CITY OF ALBUQUERQUE

June 6, 2018

Re: 3308 4th Street Apartment Building
3308 4th Street NW
Traffic Circulation Layout
Engineer's Stamp **06-04-18** (H14-D109)

Based upon the information provided in your submittal received 06-05-18, the above referenced plan cannot be approved for Building Permit until the following comments are addressed:

#### 3308 4th SREET, NW SITE PLAN FOR BUILDING PERMIT

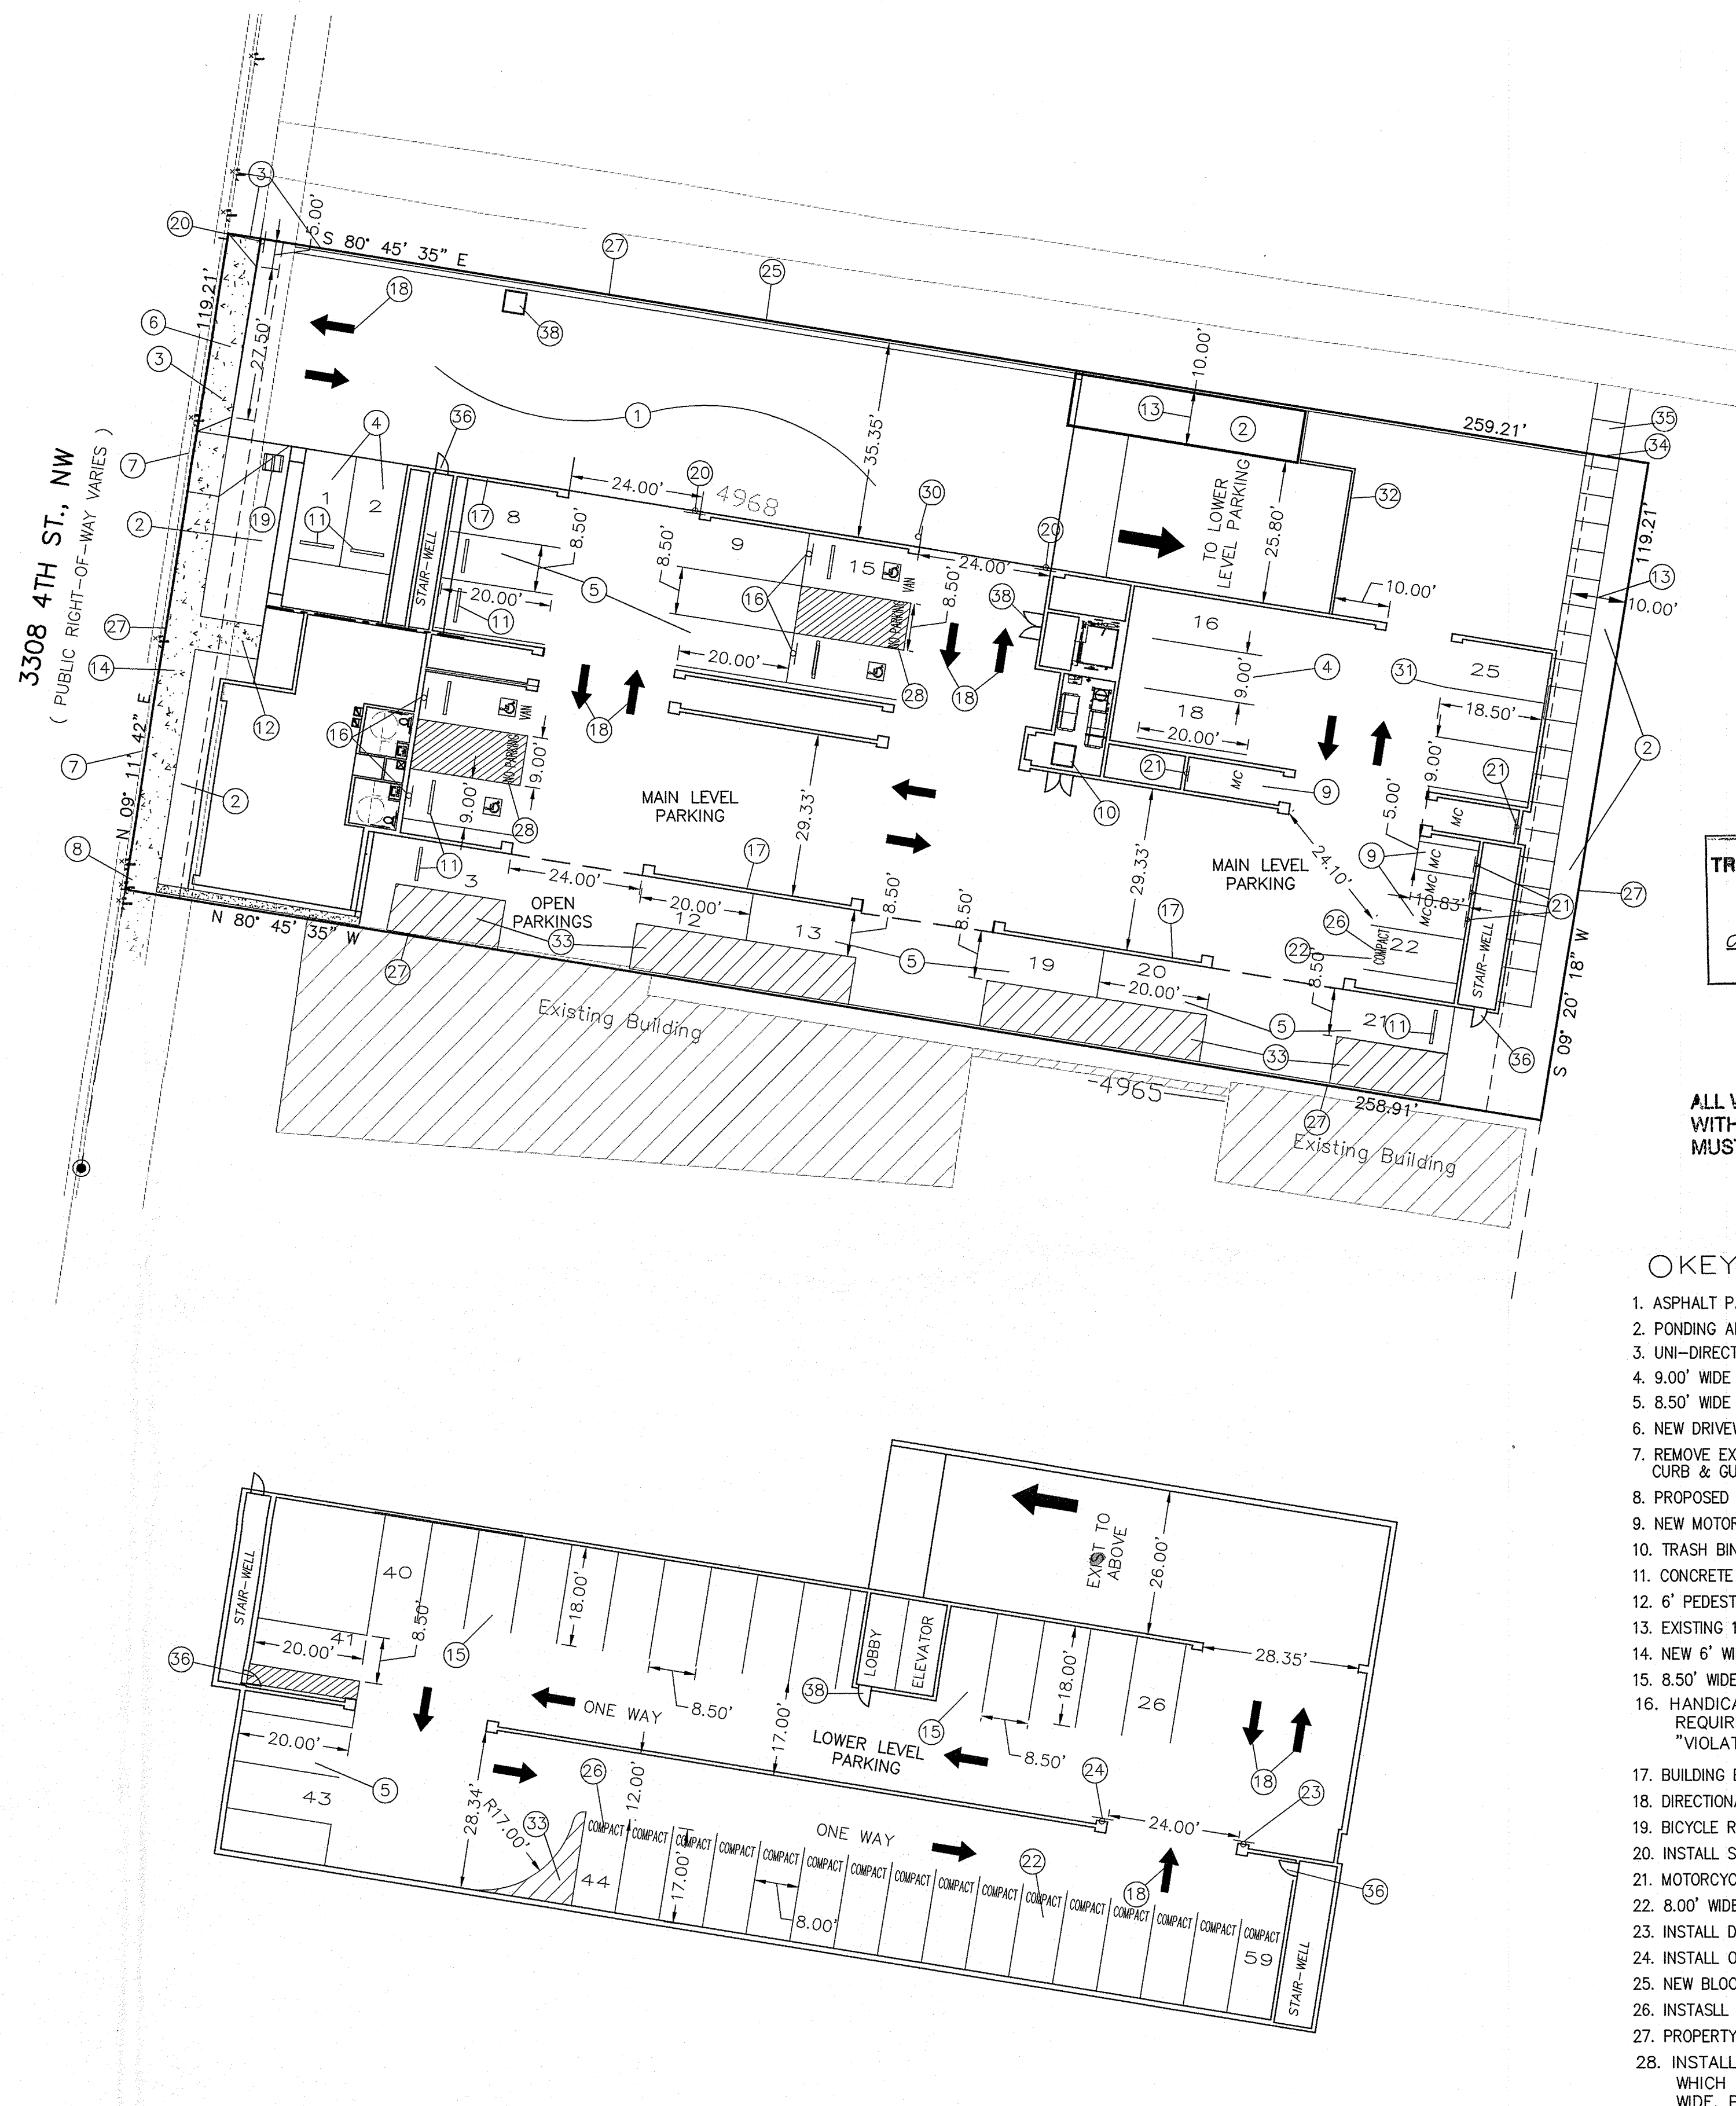
1. Please show the location of the Motorcycle parking sign on the site plan.
2. Please show the sidewalk connecting to the multi-use path.
3. Show the route refuse will use to access the trash bin.
4. Please show the locations of the doors on the stair-well and elevator. Also please label the stair-well.
5. Please provide an elevation exhibit for the parking structure showing doors and ceiling height.
